Zoe Toppin
Planning Officer, Planning

The plans which you have submitted for the above application are for a single storey side extension and loft conversion with 2 x side dormers. However, when looking at the plan the side extension is not shown on there and the proposed site plan shows as a proposed front extension.

Proposed first floor

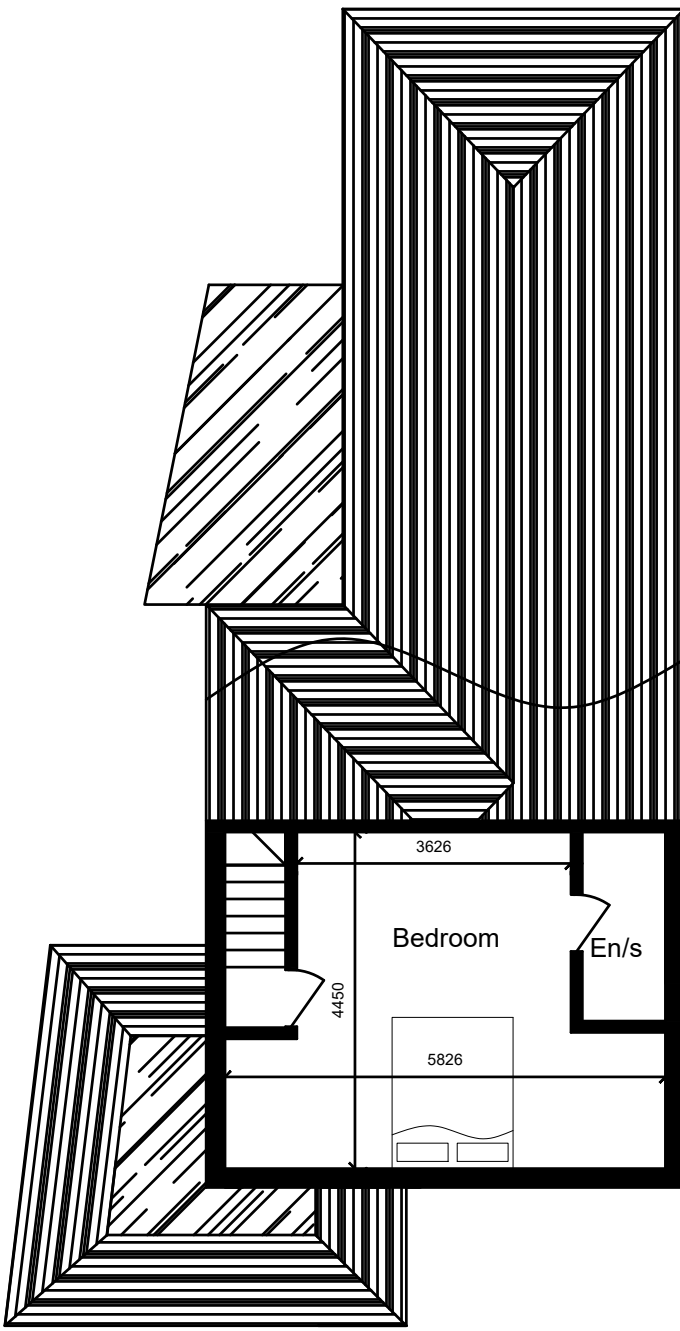
The side dormers both have windows, however the proposed first floor plans do not show windows on there.

Please see attached revised plan that shows all the windows at first floor level.
